**Application by Aquind Limited for an Order Granting Development Consent for the
Aquind Interconnector (Ref. EN020022)**

**TRANSCRIPT OF SUBMISSIONS TO ISSUE SPECIFIC HEARING 1 - draft
Development Consent Order
PORTSMOUTH CITY COUNCIL
30 NOVEMBER 2020**

Plate 3.23 - Typical arrangement of HVDC and FOC cables in roads, verges and footpaths (all measurements in mm)

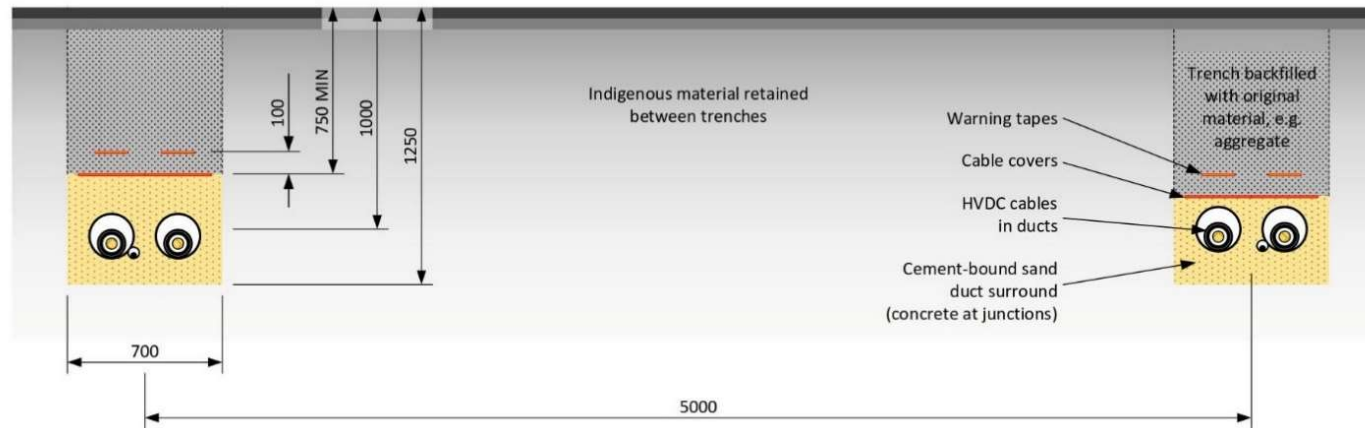
- 3.19 Turning to the second question asked by the ExA at Q3.8 concerning any need to acquire the subsoil, the highway extends to the land beneath the surface to the extent that is necessary to support / drain the highway. The LHA powers in NRSWA extend to that depth although the physical depth is not absolute and will vary depending on specific ground conditions. This will typically be in the order of a 2 - 6m depth to accommodate drainage although may extend significantly deeper to provide support. There is therefore no need to seek to acquire subsoil to a highway or easement rights in order to facilitate the laying of the onshore cable at a depth of 750mm as shown in the applicant's typical cross section.
